DECISION DELEGATED TO HEAD OF PLANNING

Application No: H02-0837-25 **Applicant:** Mr & Mrs I Smedley
Proposal: External & Internal Alterations
Location: The Manor House 5 East Street Crowland
Terminal Date: 23rd January 2026

This Listed Building Consent application is for external and internal alterations to The Manor House, 5 East Street, Crowland.

Project The Manor House, East Street, Crowland, PETERBOROUGH PE6 0EN	Drawing Title Proposed basement and ground floor plans	Scale 1:100 @ A3
Purpose of Issue Planning	Drawing Number 438-44.P21A	Date May 2025

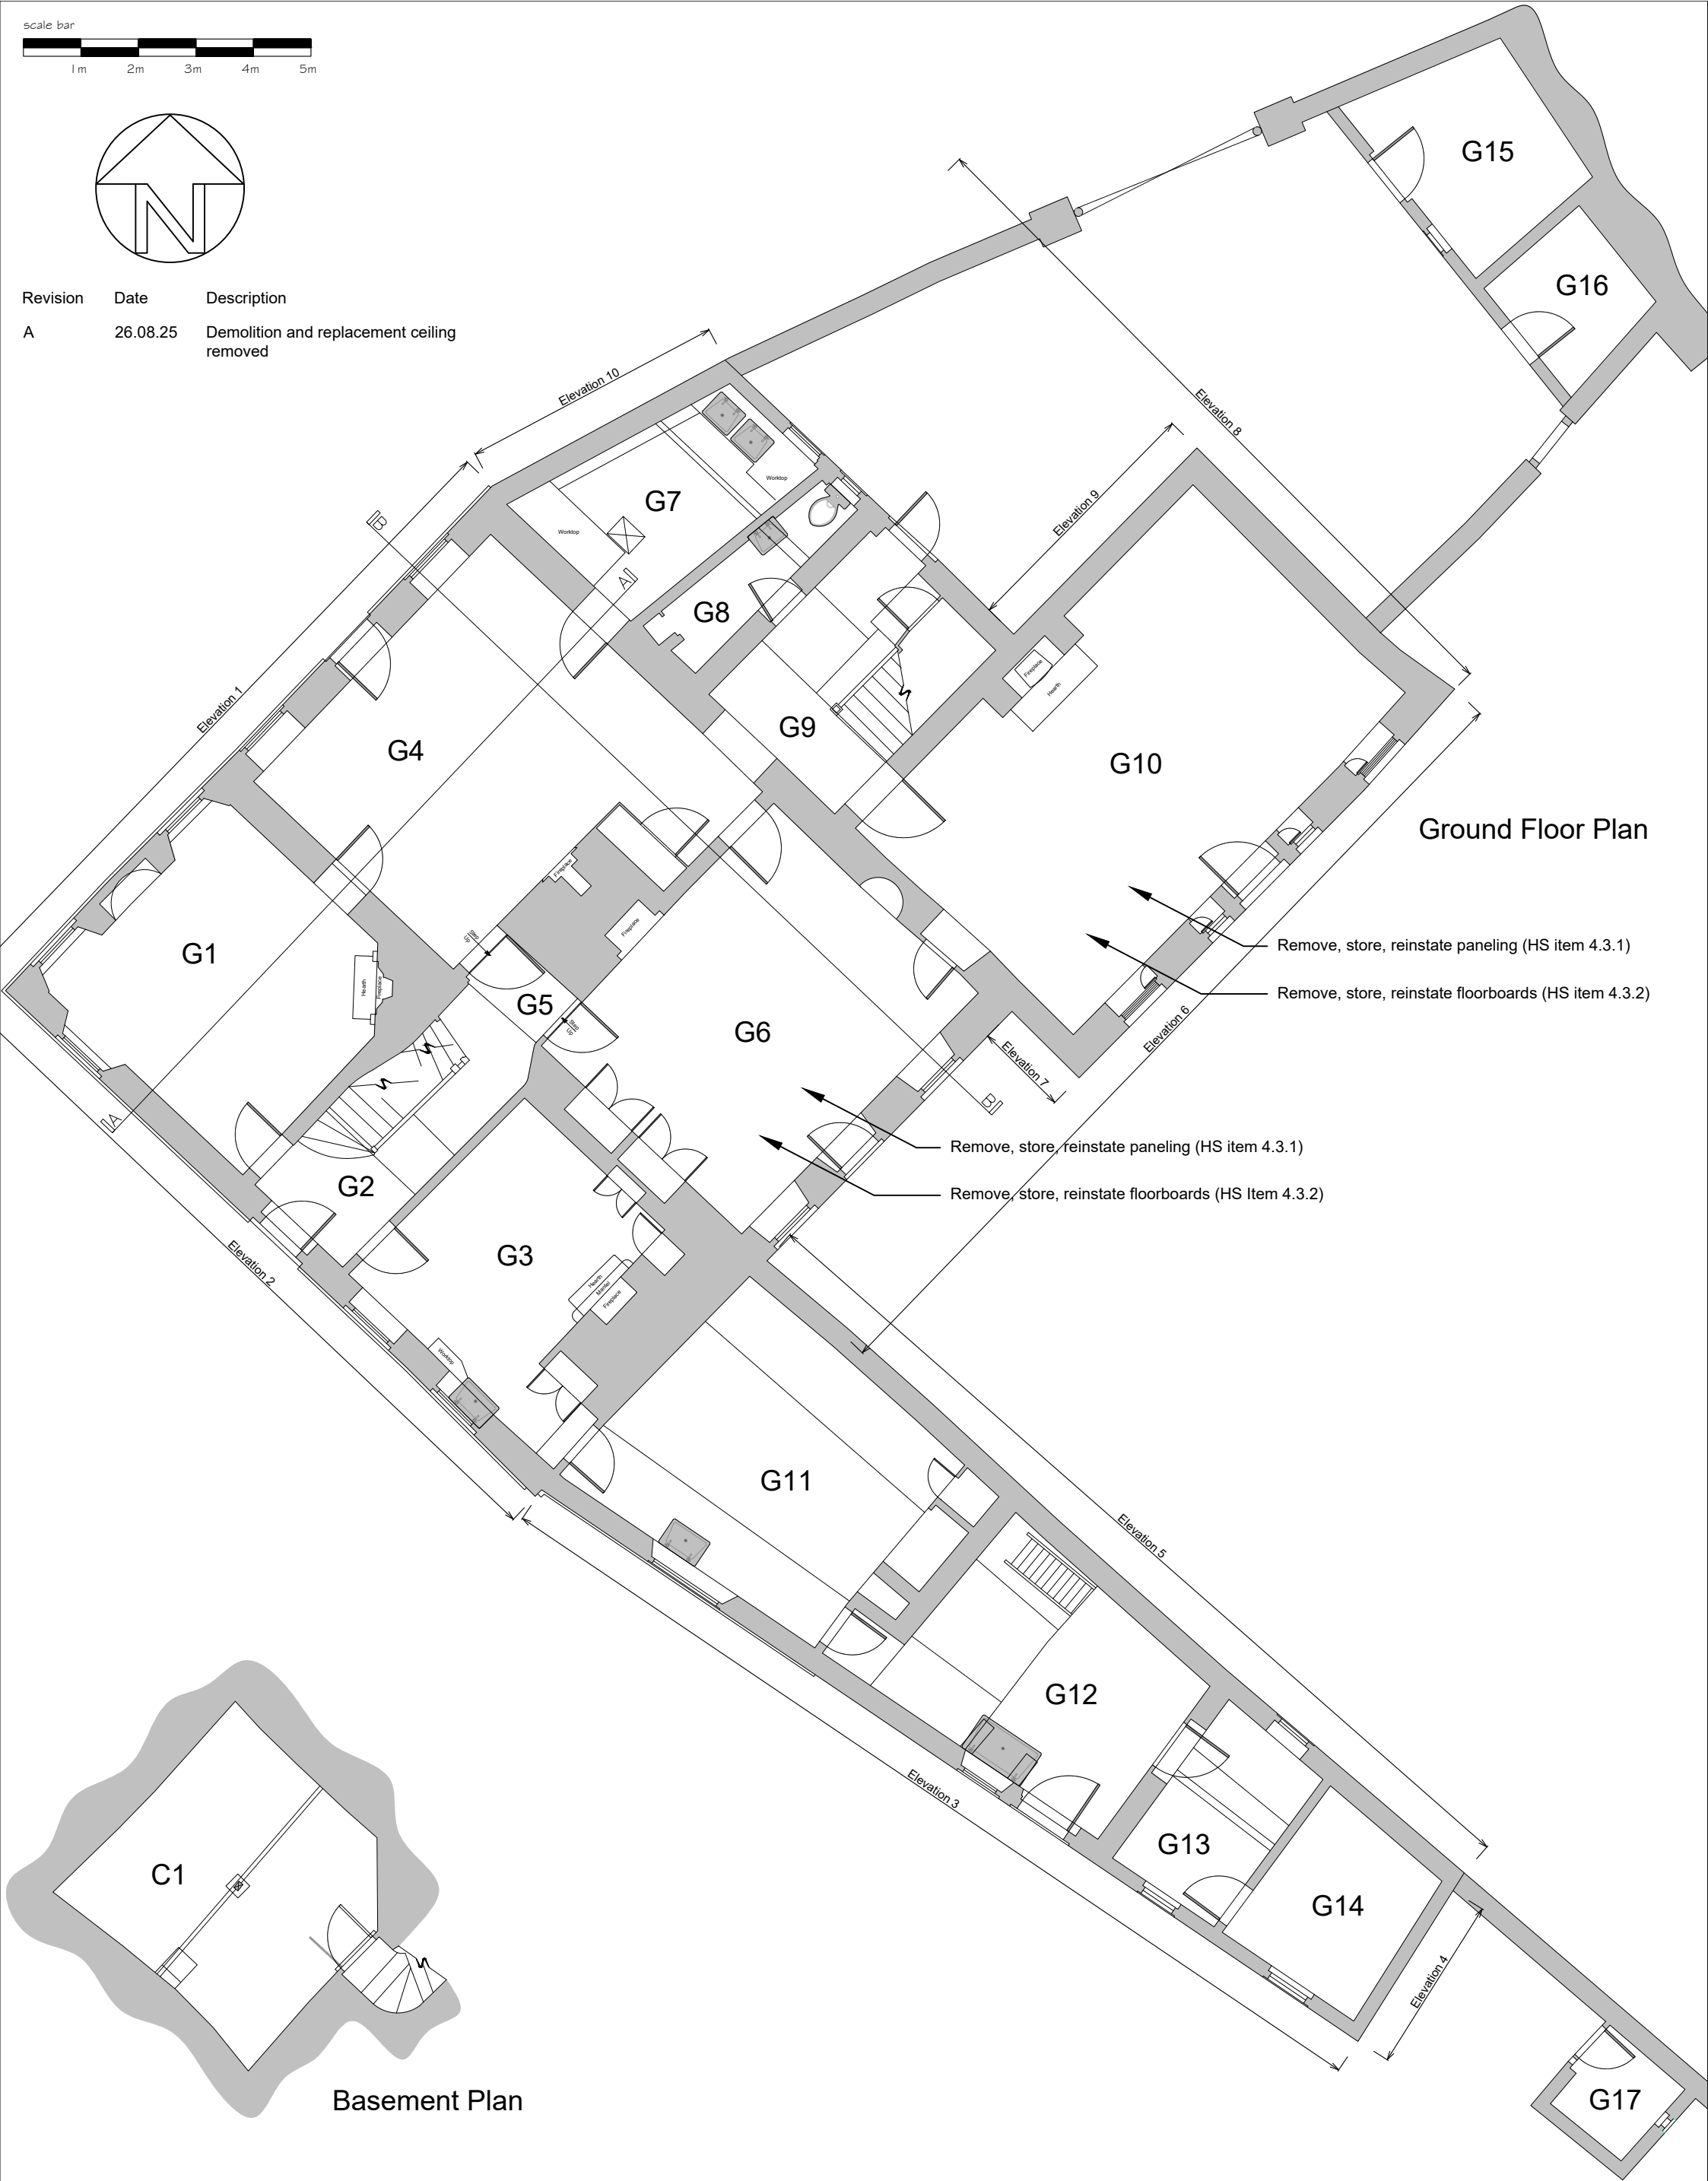
The proposed opening-up work appears to impact a large extent of historic fabric in rooms F9, G6 and G9. We note that some of the investigative work has been previously consented, however we still encourage that the extent of opening-up works is kept to the minimum required.

We recommend that further information is provided to justify the extent of panelling proposed to be removed, to assist in balancing harm against benefit and to ensure that any unnecessary harm to

On the inside there are additional proposed works, including the removal, storage and reinstatement of timber panelling and floorboard in the rooms marked as G6, G10 and F9 on plans 438-44.P21A and 438-44.P22 respectively. This work is requested purely for investigative purposes, and the consent shall be for the reinstatement of the existing back in the same order following structural investigations. Therefore, with the application of suitably worded conditions requiring the proper storage of the panels and boards and reinstatement, there should be no overall impact upon the site whatsoever.

We also previously recommended that further information is provided to justify the extent of panelling proposed to be removed. We have seen additional information regarding this (omitted accidentally from H02-0837-25 amendment application) but provided to us separately. The additional information document (Photographs - Additional Information provided by Hutton + Rostron) consists of photographic evidence of the removal of panelling from the Great Room dating to 2001. We acknowledge that panelling has previously been altered and in light of this we refer to your Conservation Officer for further guidance on this matter going forward."

Drawing Title Proposed first and second floor plans	Drawing Number 438-44.P22
--	-------------------------------------

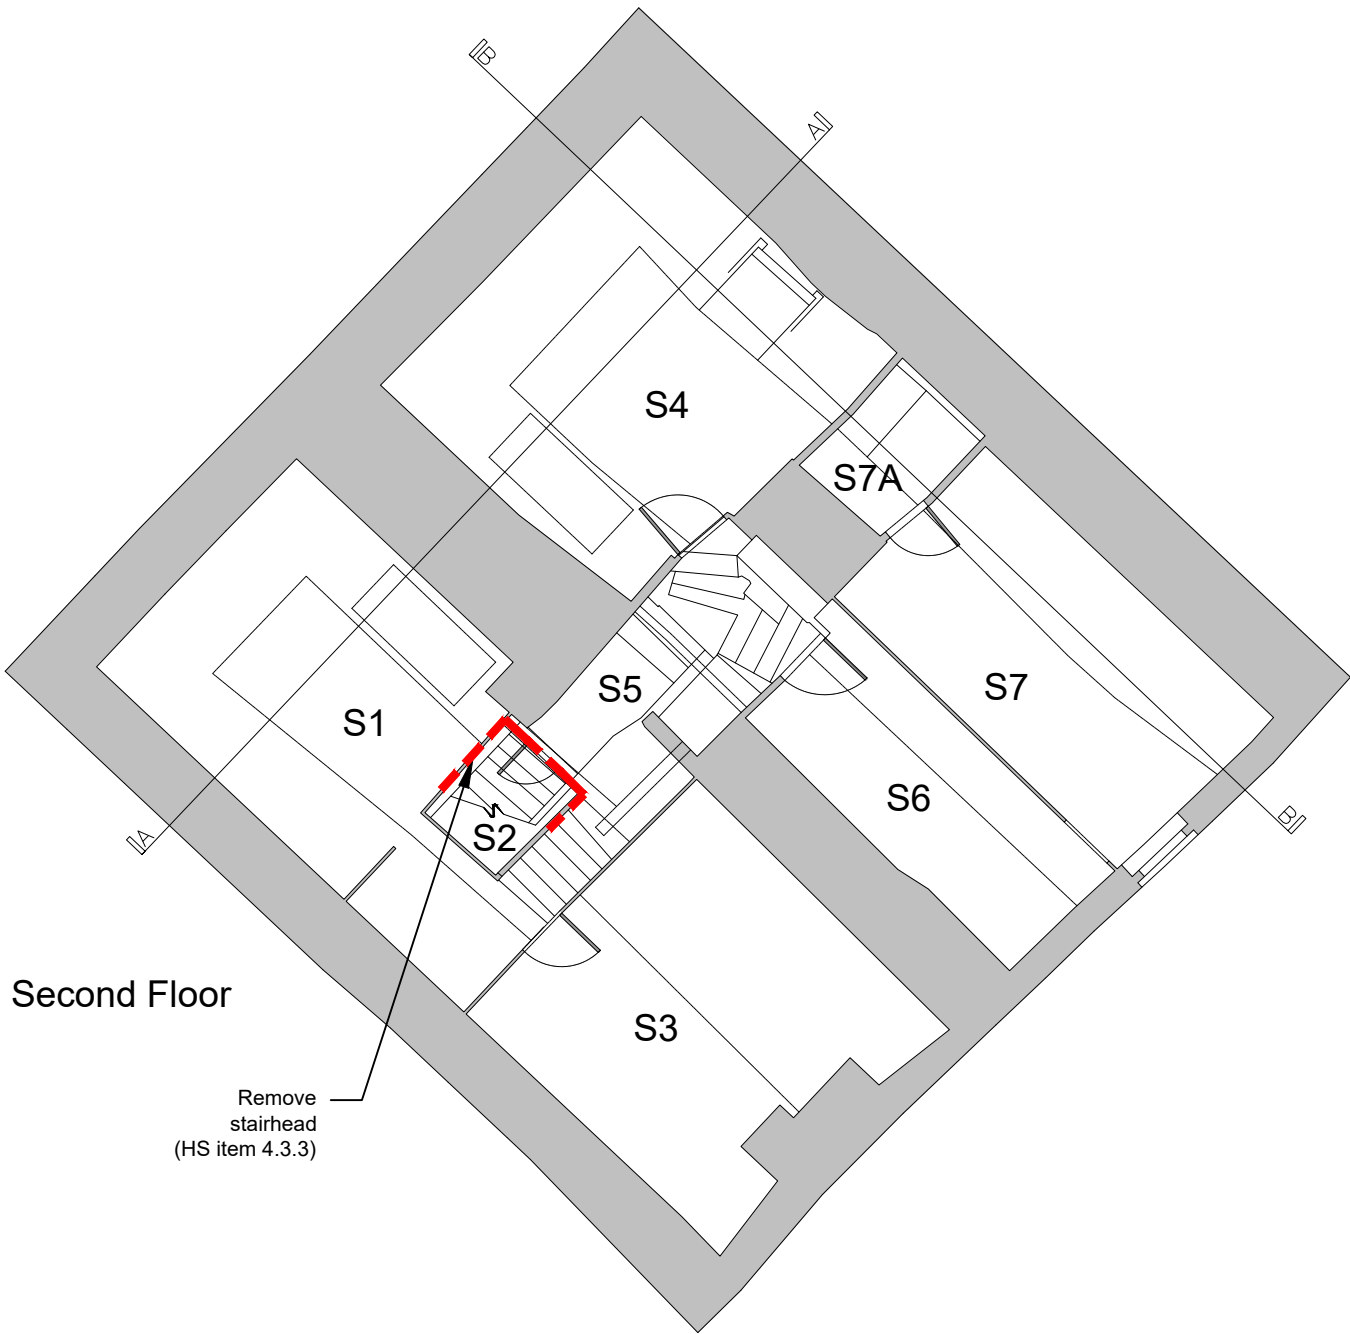
Finally, the removal of the C20th stairhead on the 2nd floor is considered to be entirely appropriate. The subdivisions are not historic and nor do they add any character to the property. Removal of this non original feature is therefore not considered to be at the detriment of the significance of the heritage asset.
